The Secretary  
NSW Department of Planning, Industry and Environment

20 July 2020

I refer to the Department's below email of 18 June 2020 regarding State Significant Development SSD-9063-Mod-1 for the Tallawong Station Precinct at 1-15 & 2-12 Conferta Avenue, Rouse Hill (Lots 293 & 294 DP 1213279) in the Blacktown LGA for Modification to the approved Concept Plan for Tallawong Station Precinct South (SSD 9063) including the following amendments to:

Figure 9:

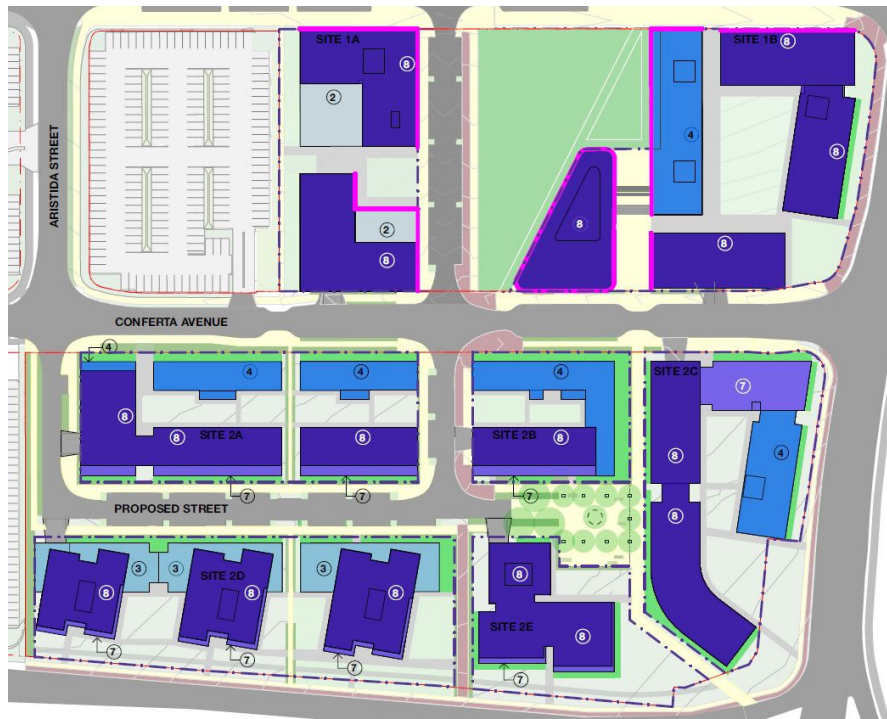
- The height / number of storeys of the buildings opposite Rouse Hill Switch Station have increased with two buildings of 4 and 7 storeys now both increased to 8 storeys (please refer to the following figures) which is contrary to the 'prudent avoidance' advice included in Endeavour Energy's submission.
